<input type="checkbox"/> Sidewalk Waiver (Form V2)		
<b>SITE PLANS</b>		<input type="checkbox"/> Waiver to IDO (Form V2)	<b>APPEAL</b>
<input checked="" type="checkbox"/> DRB Site Plan (Form P2)	<input type="checkbox"/> Waiver to DPM (Form V2)	<input type="checkbox"/> Decision of DRB (Form A)	
<b>BRIEF DESCRIPTION OF REQUEST</b>			
Apartment complex development

**RE: Sonata Unit 4 Trails Apartments  
Tracts 1, 2, and 3, The Trails Unit 4  
Second DRB Submittal**

RESPEC, agent for Sonata Trails, LLC, owner of the above referenced property, is requesting approval from the Development Review Board (DRB) on this Site Development Plan submitted for your consideration. This is the second submittal to the DRB for this project. The first hearing was held on June 3, 2020. Below is a response to comments received at the first DRB meeting.

SHEET TITLE:
CONCEPTUAL SITE UTILITY PLAN

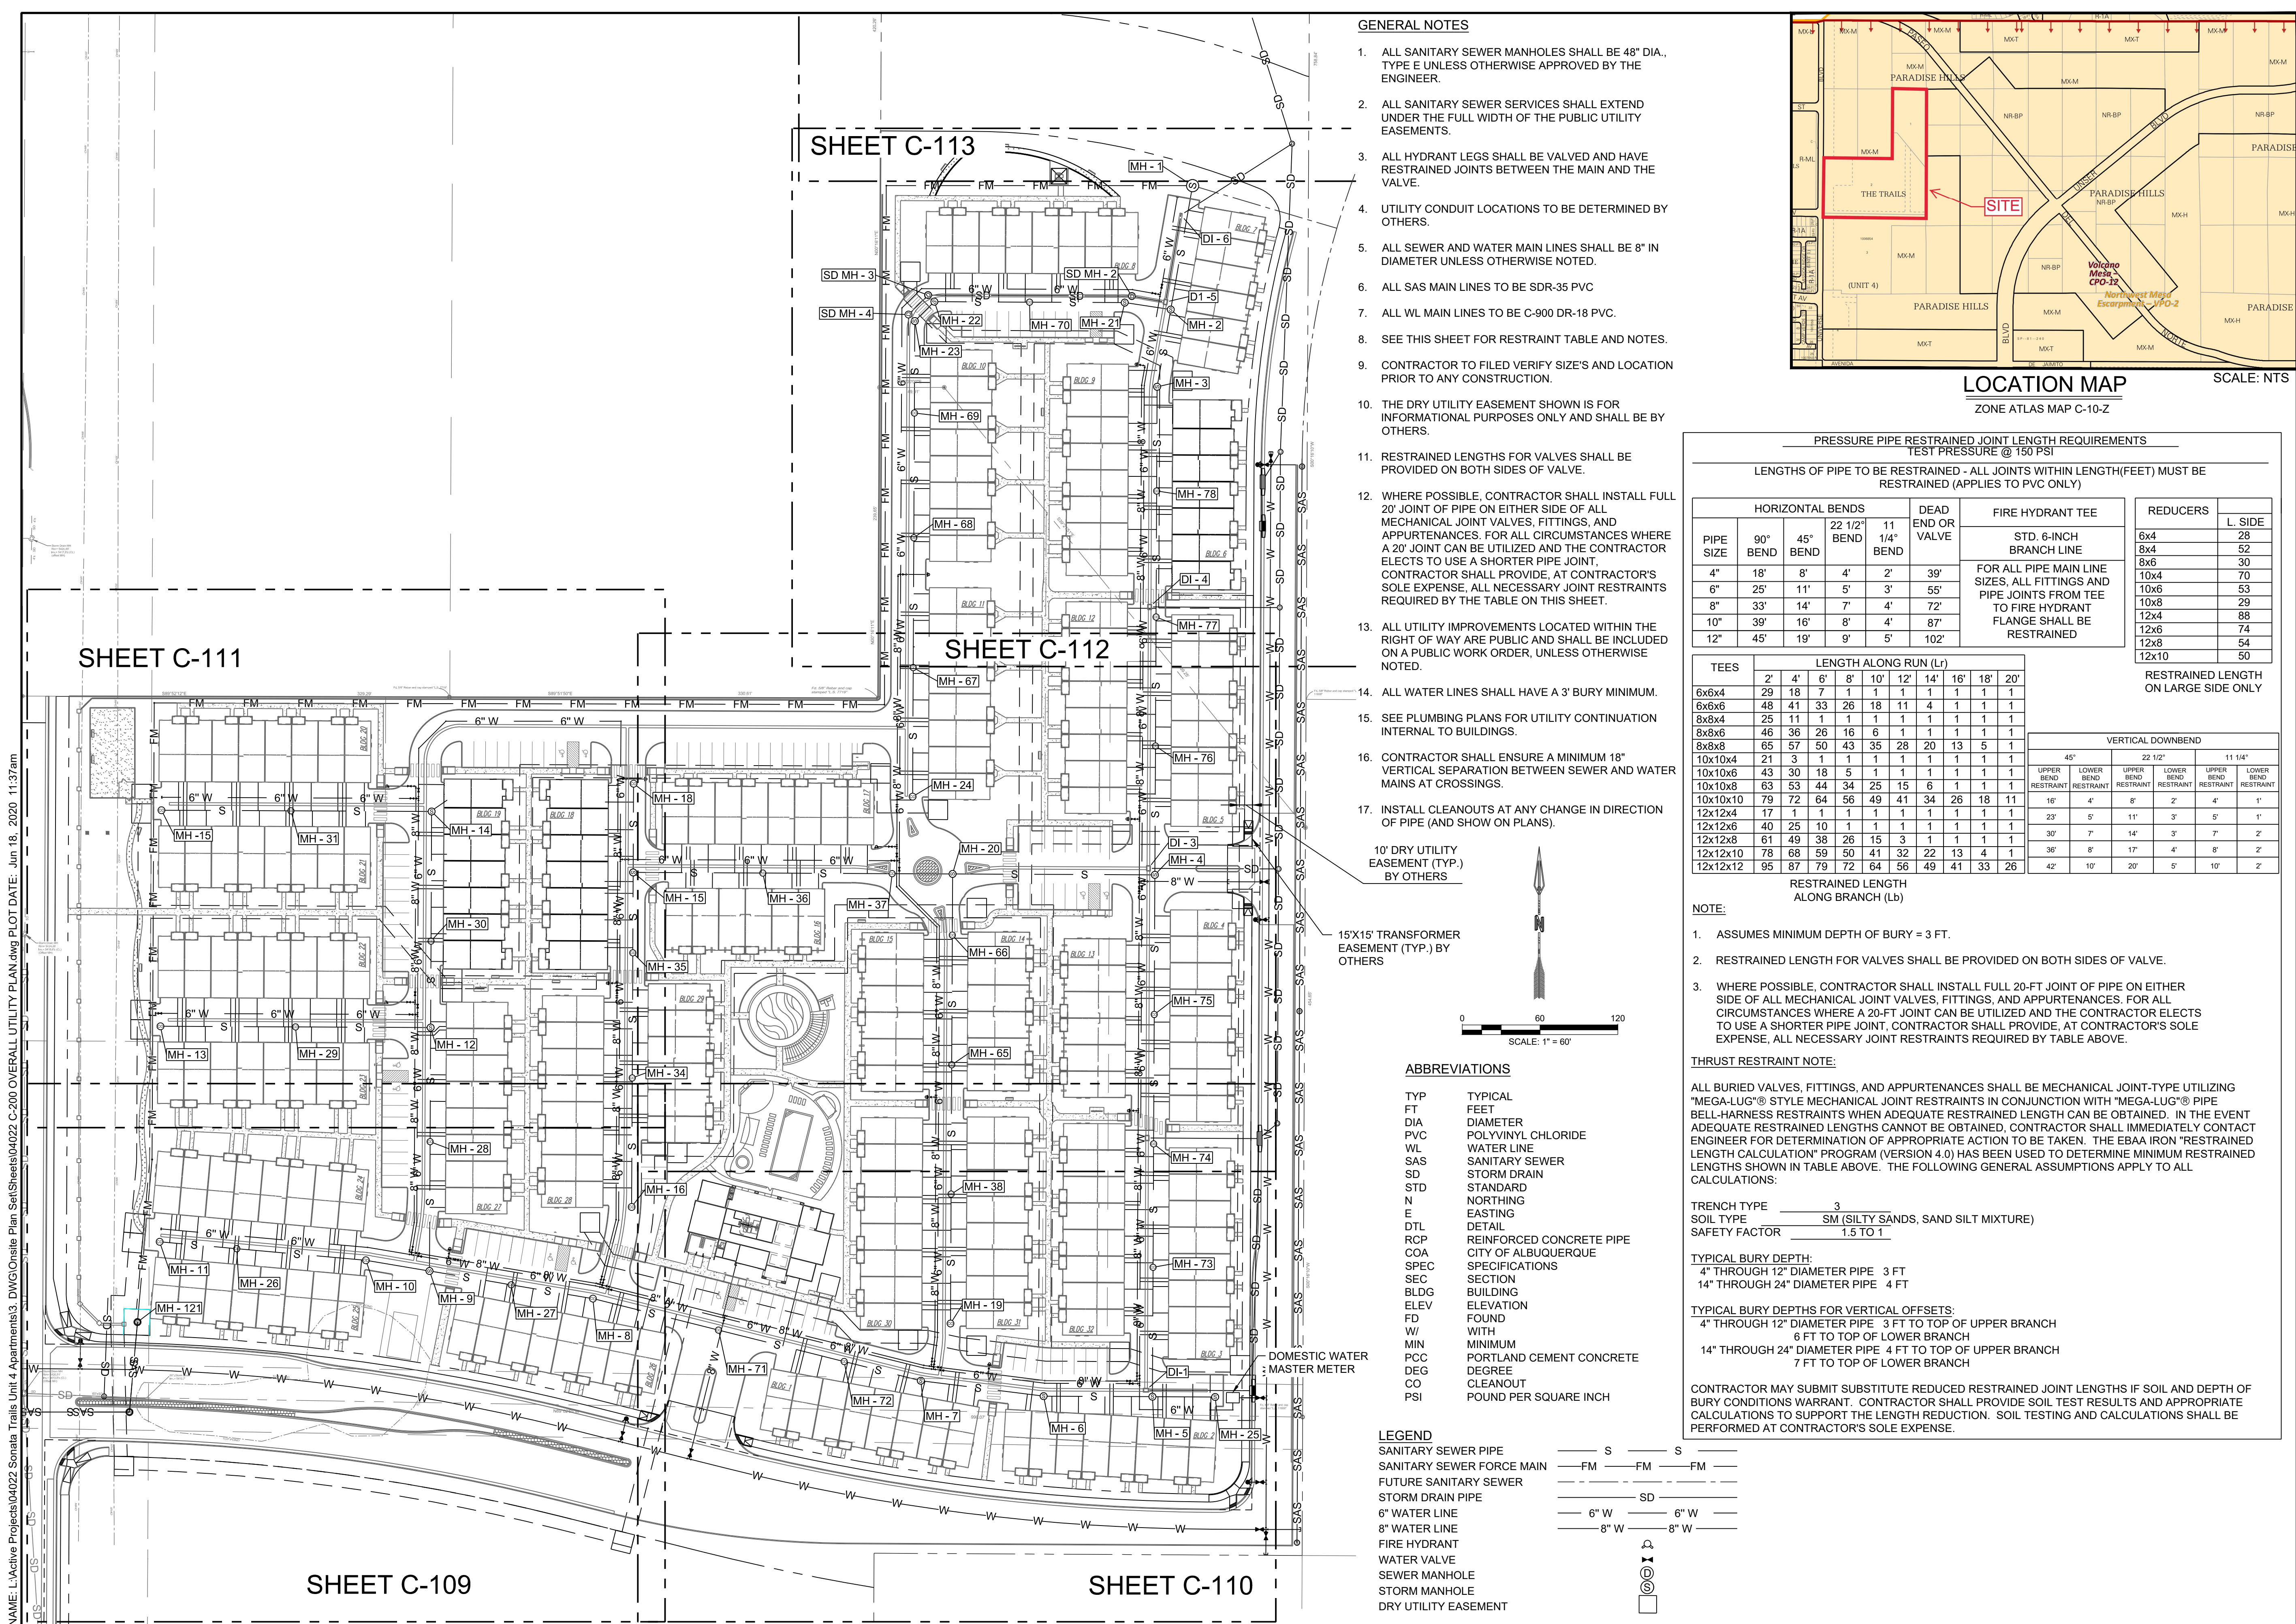
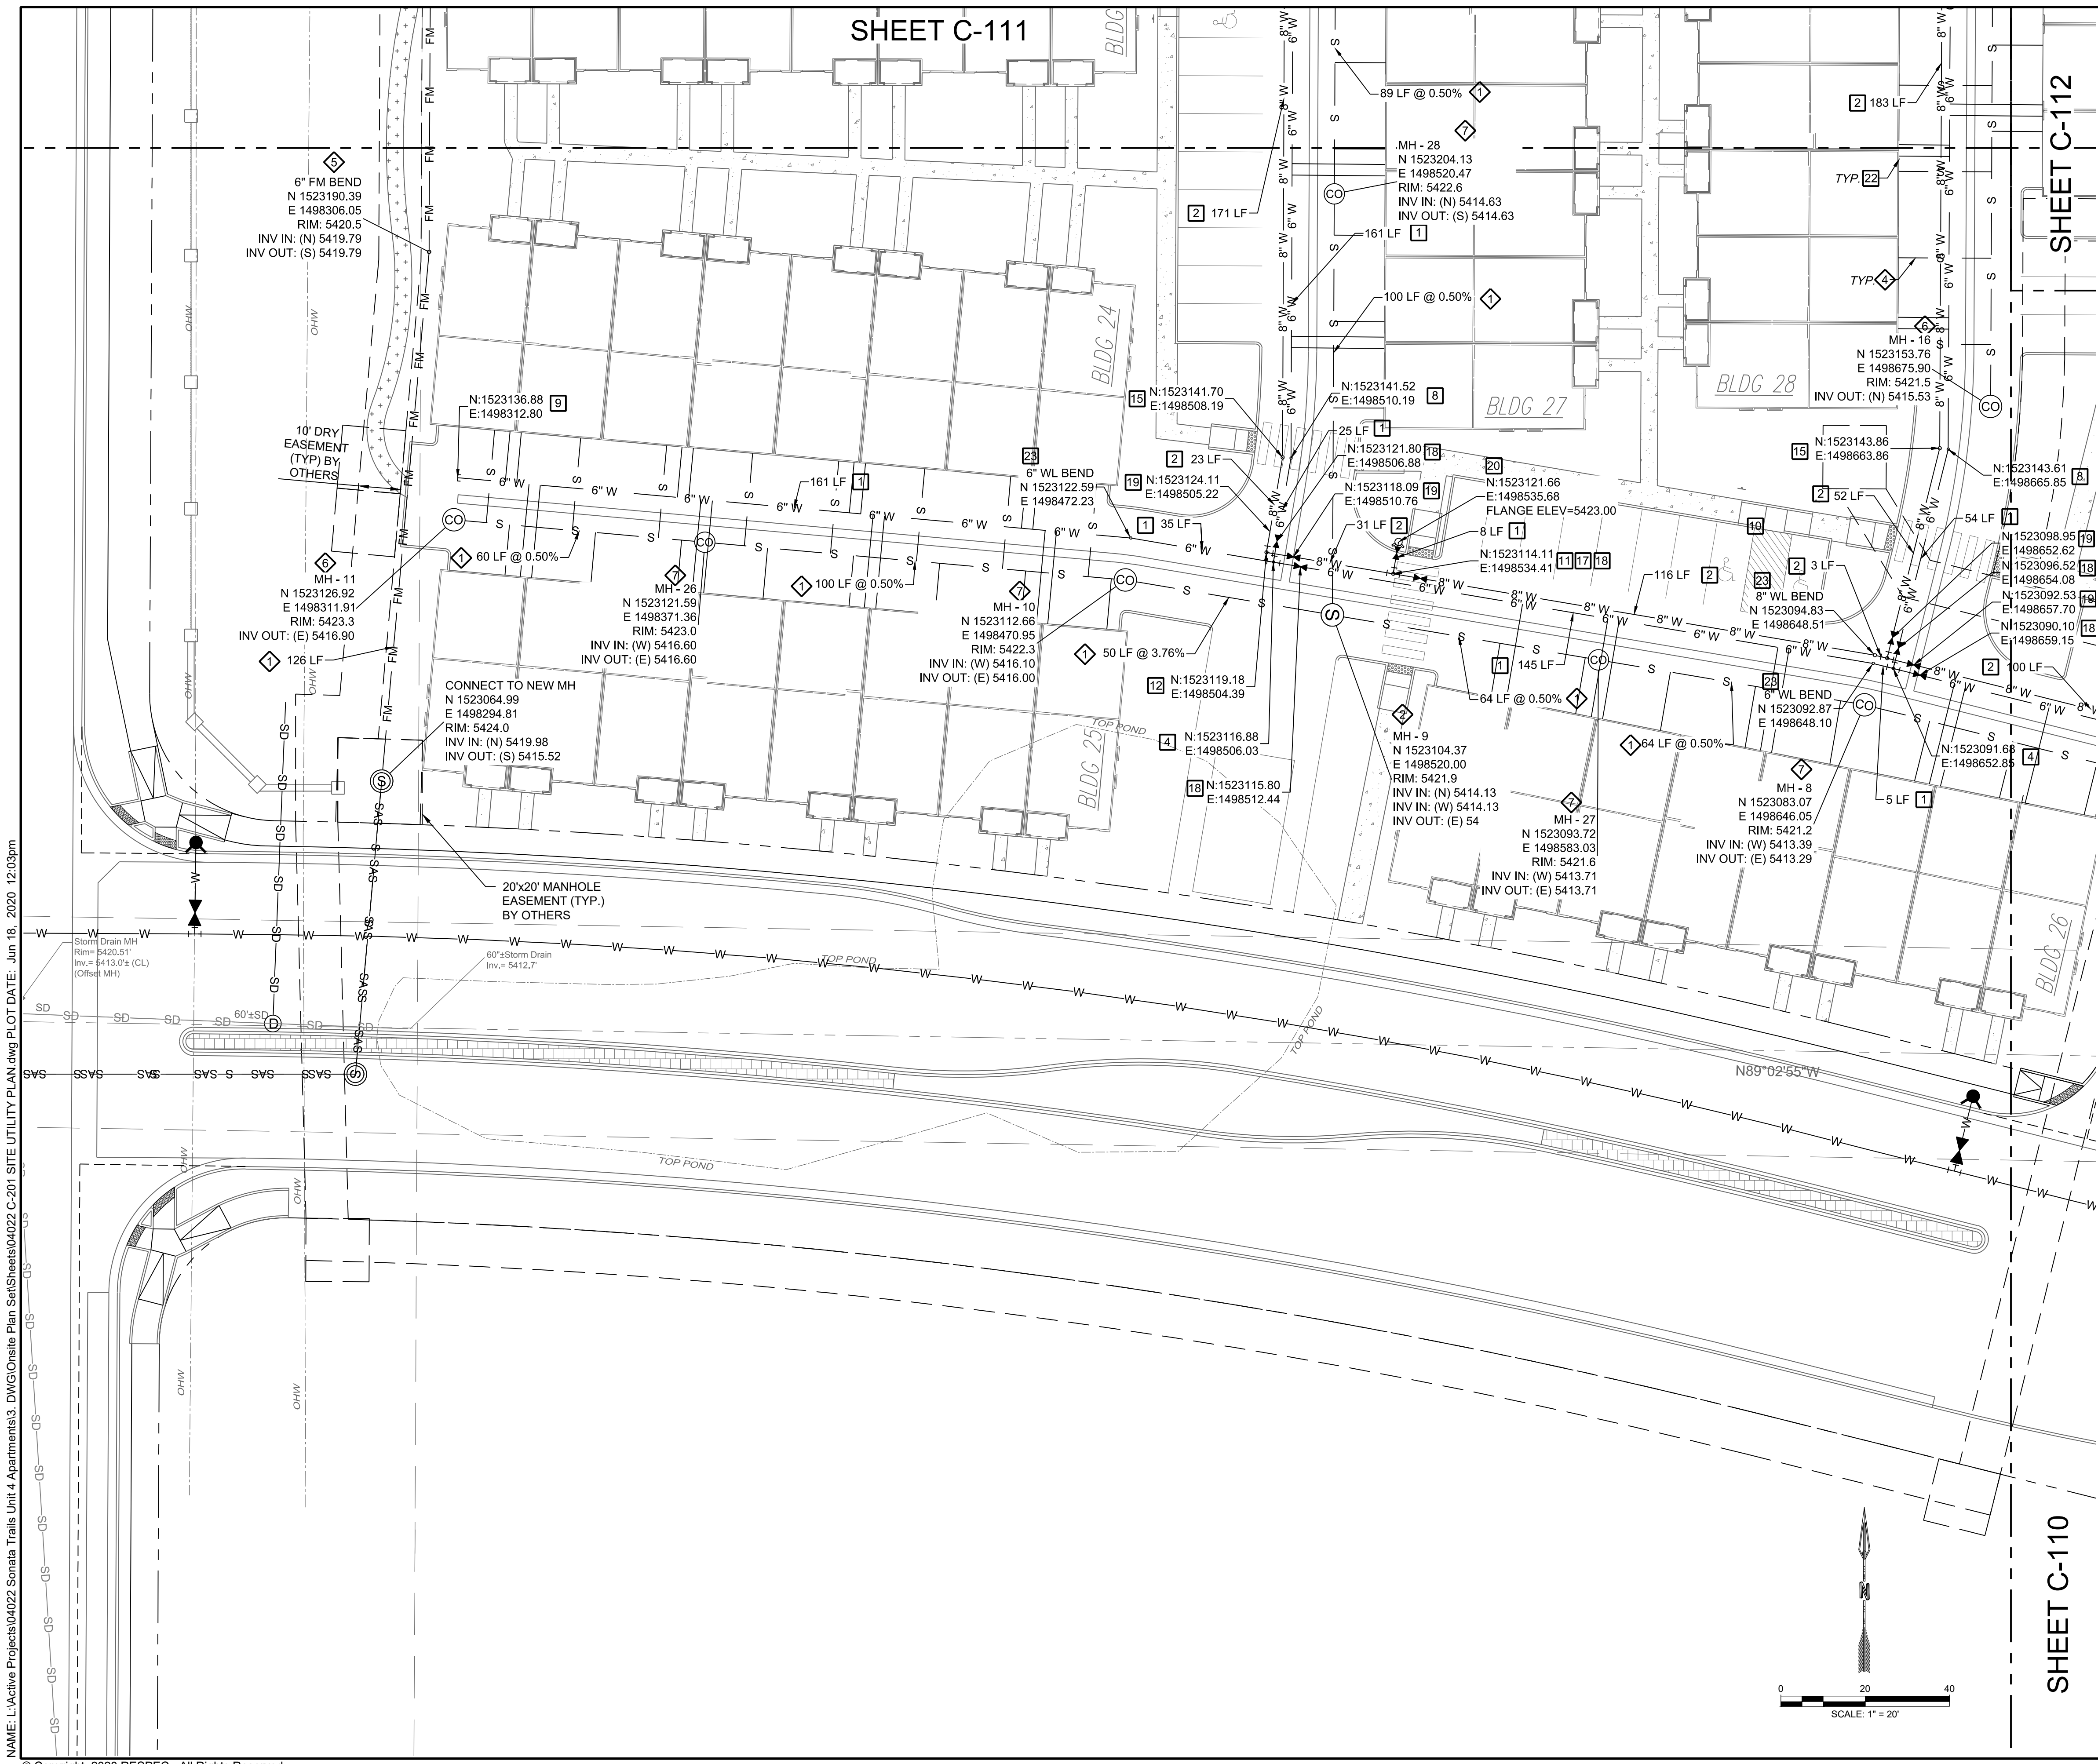
3. Utility Plan
    - a. A meter is shown for each unit. This is not consistent with a previous proposal for a previous request for availability statement which included master meters for the entire development. The proposal for individual meters for each unit (which is not consistent with the calculation for UECs in the Rate Ordinance) appears to be significantly more costly.

- i. The onsite public waterline can be minimized depending on the outcome of metered service locations. The apartment complex can be served by either a master meter or a combination of meters to serve buildings.

- b. Coordination with the engineer is taking place to understand the best routing of sanitary sewer for the subject development as it has an impact on the surrounding area. The alignment along Chatsworth Dr. is being researched to better understand a potential high point and ability for adjacent properties to discharge to this line.

- c. A proposed lift station is shown at the northwest corner of the subject development which ultimately discharges to proposed public gravity sanitary sewer along Treeline Ave.

- i. Considering the potential interim condition with the private lift station, the Utility Plan should show the phases.
      1. The interim use of a private lift station and the trigger to eliminate the private lift station and discharge to public sanitary sewer that flows to the proposed interceptor along Paseo Del Norte/Avenida De Jaimito

when it is available may need to be detailed in the development agreement.

- 1. Public sanitary sewer along Treeline Ave. that flows east is not shown on the Utility Plan.
- / If I remember correctly, a public sewer in Tree Line was not required in the previous serviceability statement. Will this be a requirement with the new serviceability letter? If so, who will this sewer serve? No change has been made to the utility sheets.

- e. Public waterline and sanitary sewer along the frontages of Treeline Ave. and Chatsworth Dr. are not shown to be proposed on the Utility Plan.
- / Public waterline and sewer are shown in Chatsworth Dr. and public waterline is shown in Tree Line Ave. See revised utility sheets.

- f. Label proposed lift station and onsite sanitary sewer as private (both force main and gravity sewer). Based on the determination of the onsite waterline, public waterline and private waterline shall be labeled as well.

- / The meters for each unit have been removed. We are proposing a master meter at the southeast corner of the development. See revised utility sheets.**

- / Detail has been added to demonstrate the phases for the private sanitary sewer. See revised utility sheets, specifically C-113.
  - d. Please confirm if the proposed manhole south of existing manhole C10302 can be eliminated by extending east directly from the existing manhole along Treeline Ave.

- / All utilities on-site will be private and all utilities within the right-of way will be public. See revised note 13 on sheet C-108.
